Inspector's Report ABP306105-19

Protected Structure, whether the replacement of a rooflight is development and whether or not it is exempted development.

68 Brighton Road, Rathgar, Dublin 6.

PHOTO No 1

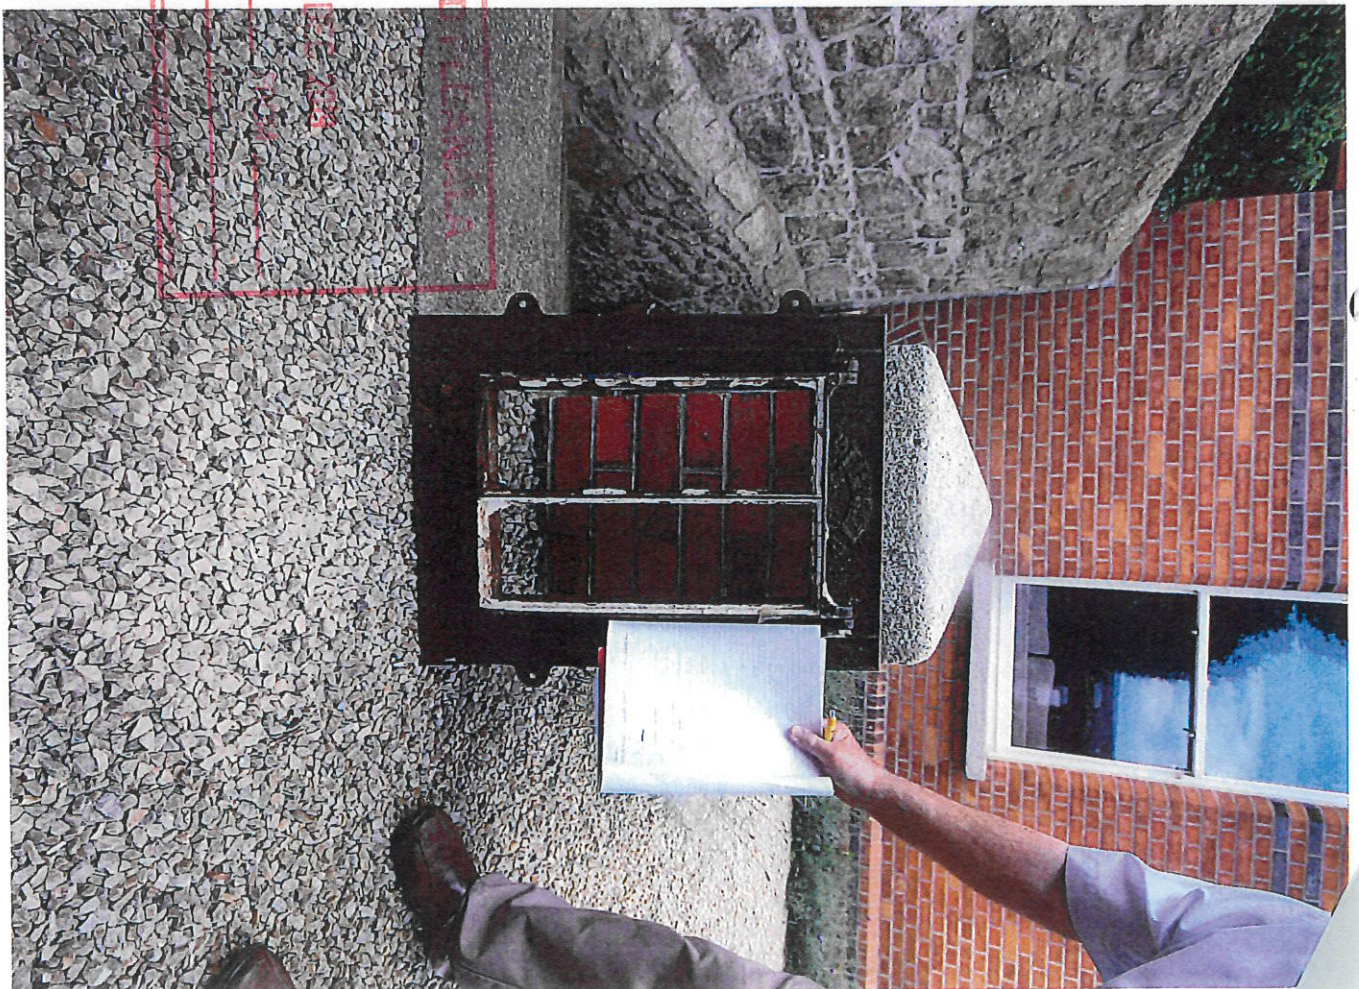
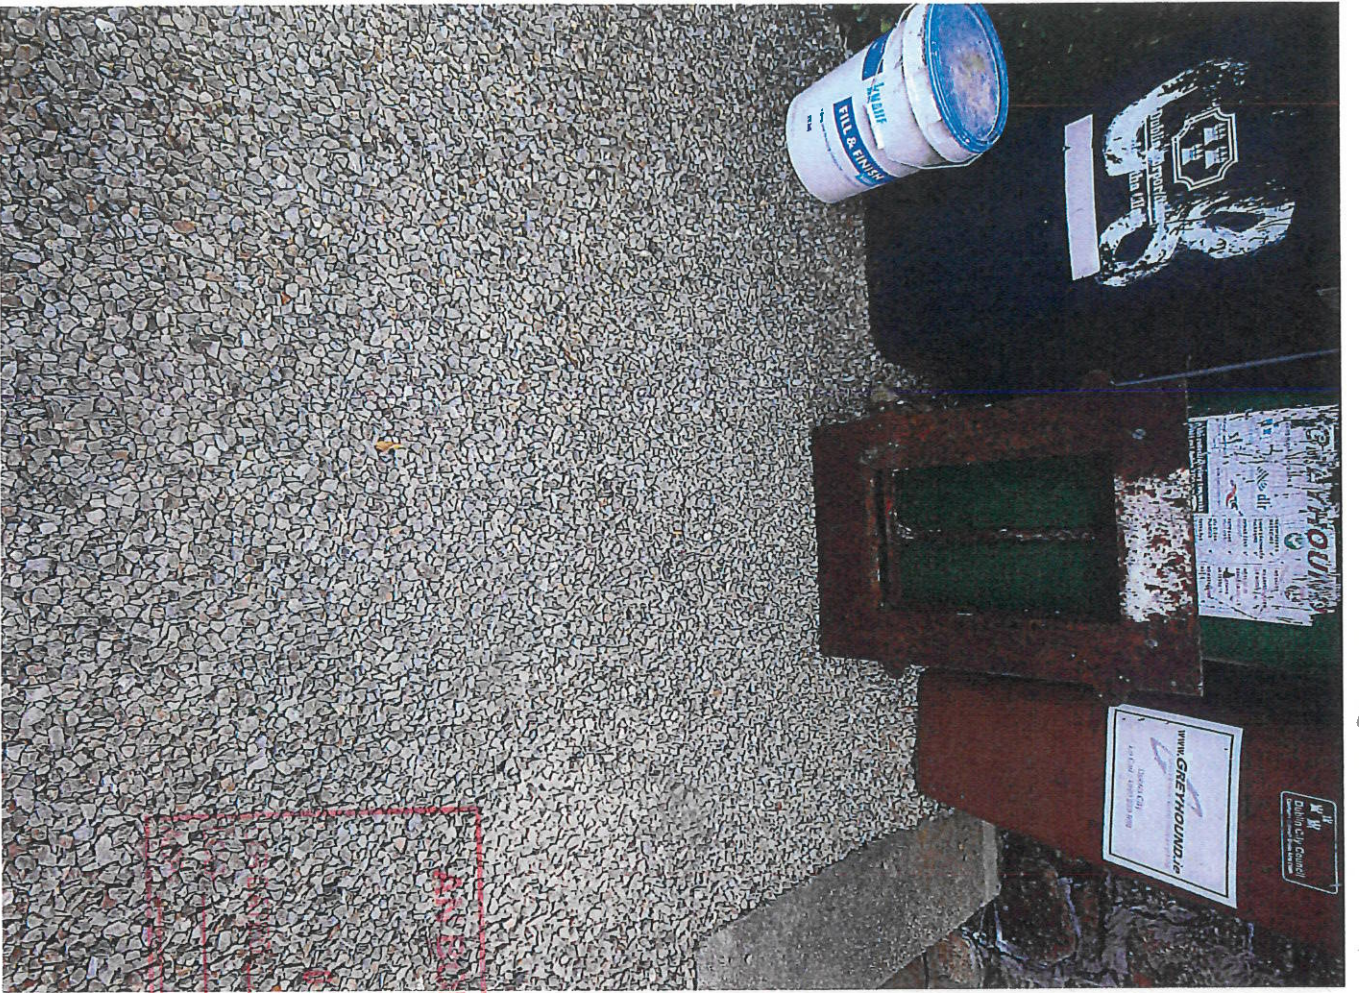
8.2.4. I fully accept the referrer's contention that there are numerous buildings along Brighton Road including buildings directly opposite the site which are also protected structures and incorporate velux windows/rooflights on the front roof pitch. However, having regard to the existing symmetry and architectural uniformity of No. 68 and 69 Brighton Road, I would consider that the insertion of a rooflight within the roof pitch of one of the said dwellings has altered the symmetry balance and uniformity in the architectural character of the pair of semi-detached Victorian dwellings. It is apparent from the information contained on file and the photographs attached to my site inspection that No. 69 does not incorporate any rooflights on the front roof pitch of the dwelling. The incorporation of a rooflight on the subject site on the prominent and highly visible front slope of the roof pitch in my view materially alters the character of the building particularly in the context of the adjoining dwelling to the north. I would therefore agree with Dublin City Council's conclusion that the proposed development would not come within the meaning of either Section 4(1)(h) or Section 57(1) of the Planning and Development Act 2000 and that the proposal would materially affect the character of the protected structure.

- 8.2.7. I note that a photograph of the said frame is contained in the submission to Dublin City Council and is also attached as a photograph to the submission to the Board. No information however has been provided which would indicate that the said rooflight was part of the original structure. The rooflight in question could have been inserted at a later date and therefore does not form part of the Victorian structure. I further note that no such rooflight is apparent on the adjoining dwellinghouse which to my mind would suggest that the rooflight may not have formed part of an original feature of the dwellinghouses in question. In the absence of photographic evidence showing the rooflight in situ on the roof profile or indeed architectural drawings relating to the original house I cannot conclude beyond reasonable doubt that the rooflight in question is a reinstatement of an original feature associated with the dwellinghouse.
